**Staff Report Allen Shoreline Variance Permit
(SV-25-00001)**

TO: Kittitas County Hearing Examiner
FROM: Zach Torrance-Smith, Staff Planner
RE: Allen Shoreline Variance (SV-25-00001)
DATE: May 14, 2025 (Hearing Date)

Requested Action: Applicant is proposing a minor deck addition to an existing Single-Family Residence. The net addition to the deck will be 179 square feet. A smaller 63 square foot deck will be removed. The project also includes a remodel to the interior of the Single-Family Residence, with no increase to the existing footprint. This work is proposed within the Shoreline Residential Shoreline of the State of the Yakima River.

JASON ALLEN
 SITE PLAN

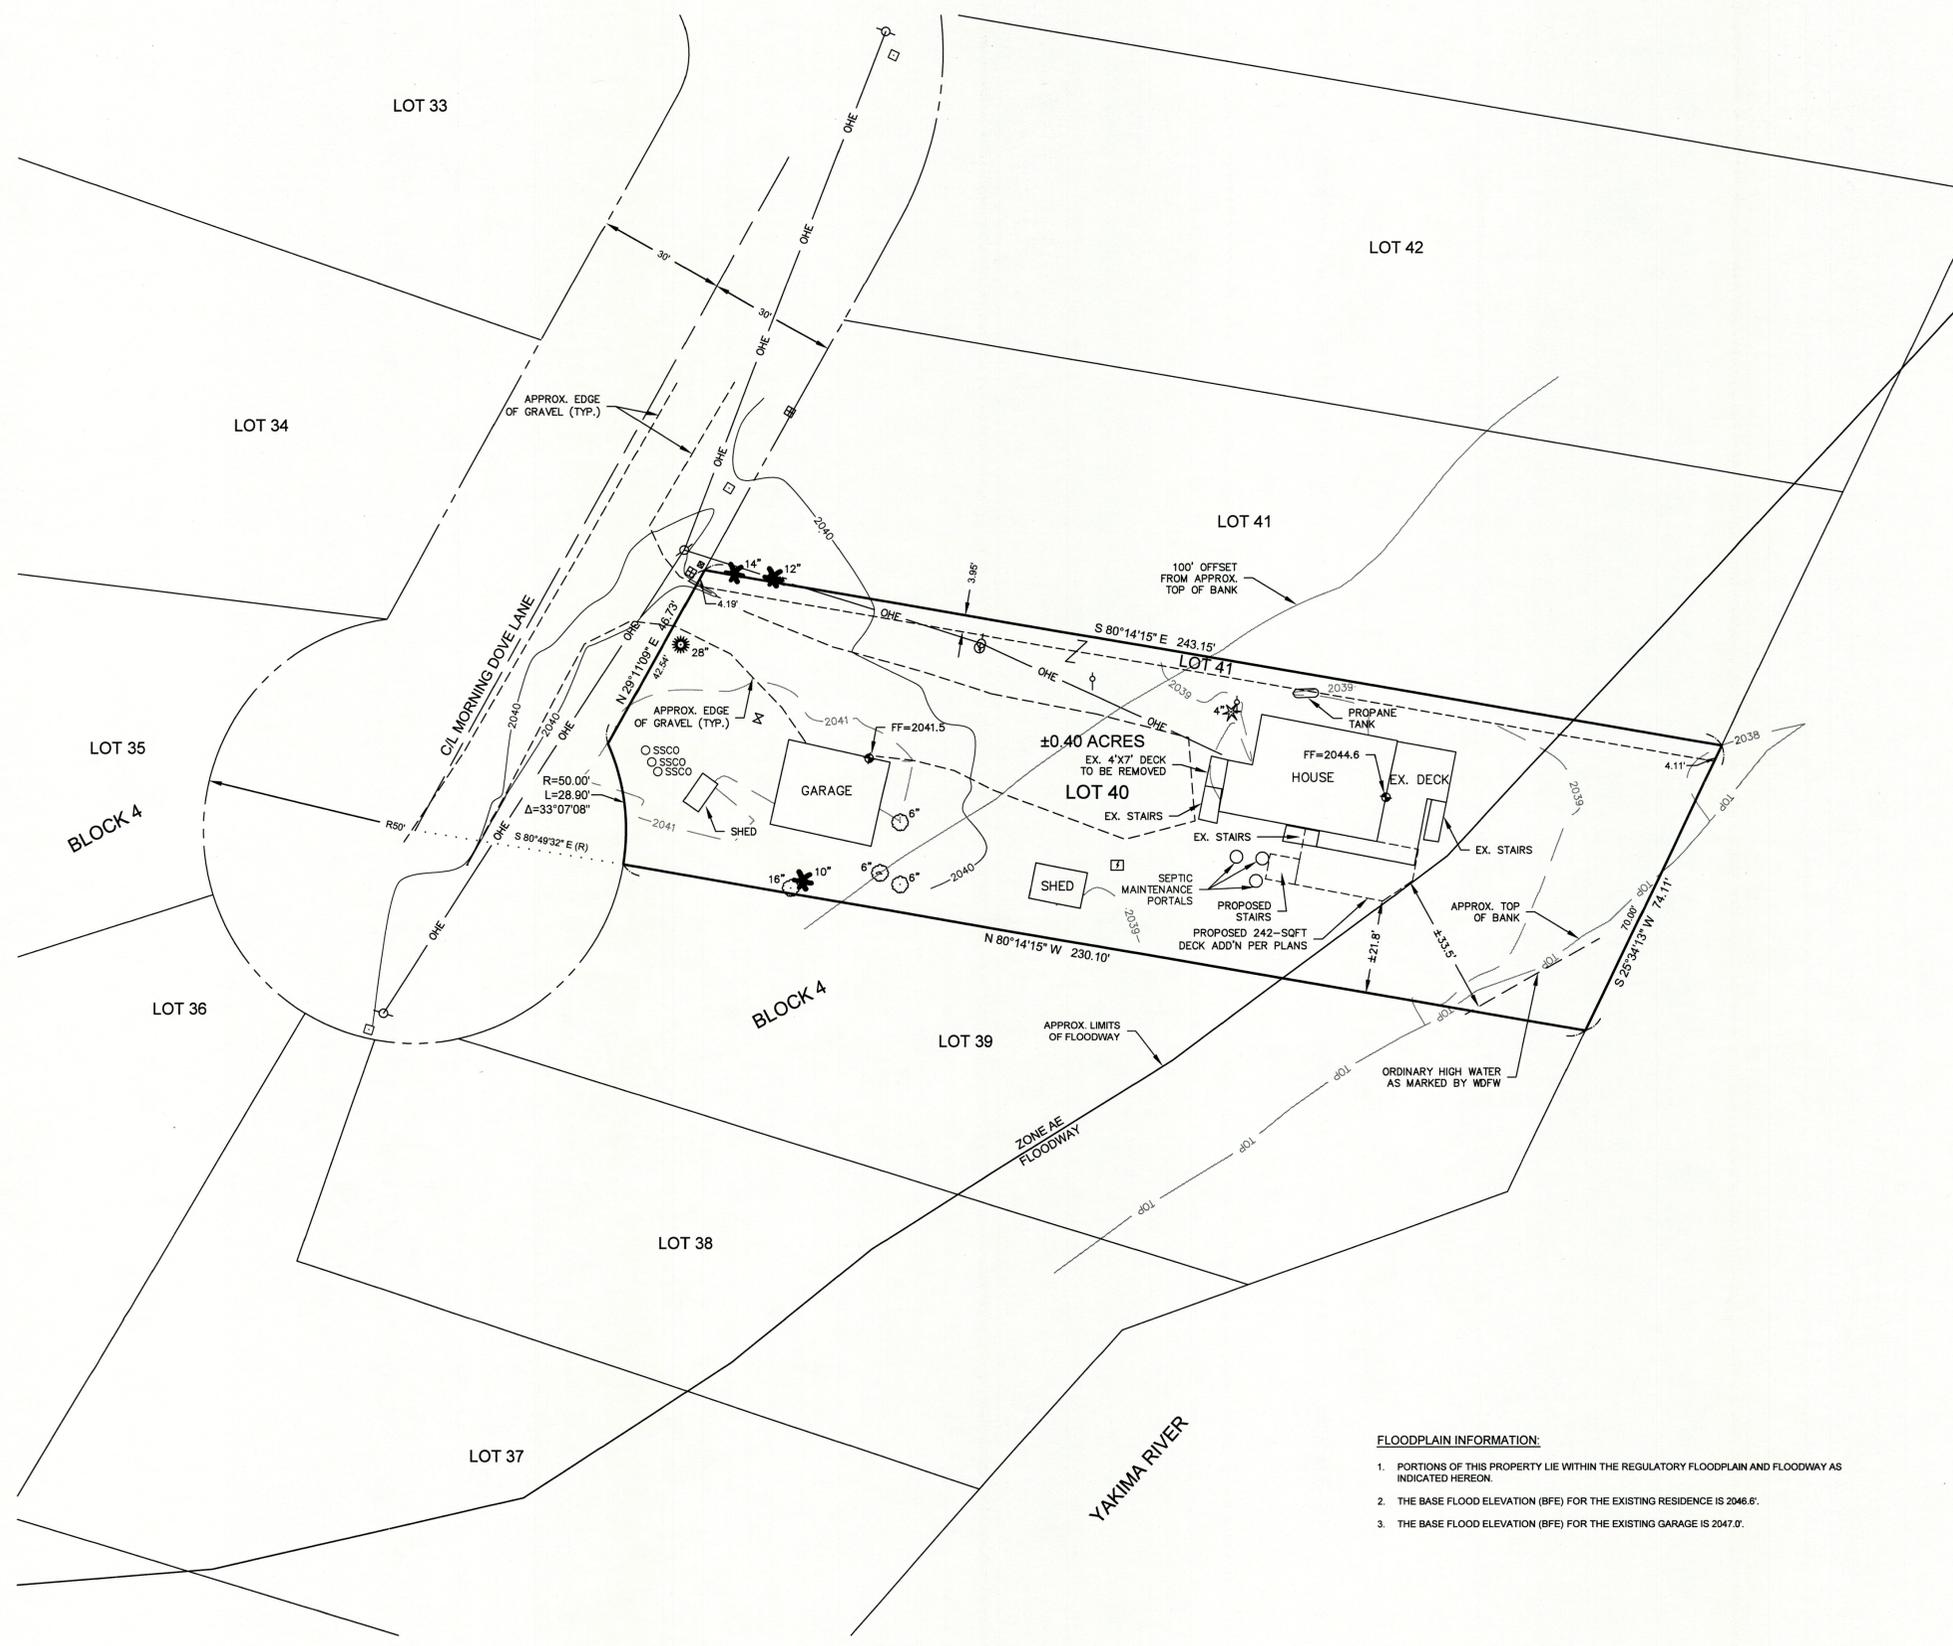
Staff Response: Staff finds that the application of applicable Master Program regulations does not significantly interfere with the reasonable use of the property. A desktop review revealed that the proposed location is not the only place a deck could be built and further encroachment into the shoreline buffer is not justified in this case. As such, CDS finds the application is not consistent with KCC 17B.07.060(4)(b)(i).

Staff Response: Due to the potential to relocate the deck in a manner that does not expand upon an already non-conforming use, the proposed project does not demonstrate unique conditions specific to the project parcel. CDS finds the application is not consistent with KCC 17B.07.060(4)(b)(ii).

Staff Response: CDS anticipates this expansion to adversely impact the shoreline environment as it is an expansion of an already non-conforming use. This encroachment would not be adequately mitigated through riparian plantings along the Yakima River.

Staff Response: The applicant is seeking to expand upon an existing non-conforming use that is not typical of the surrounding neighborhood. Denial of this variance will not adversely impact the ability of the applicants to utilize their property for residential purposes, similar to many property owners in the area. Approval of this shoreline variance would constitute a special privilege not enjoyed by other property owners in the area.

Applicant Response: *Applicants provided a horizontal profile showing that the project will expand waterward toward the OHWM.*
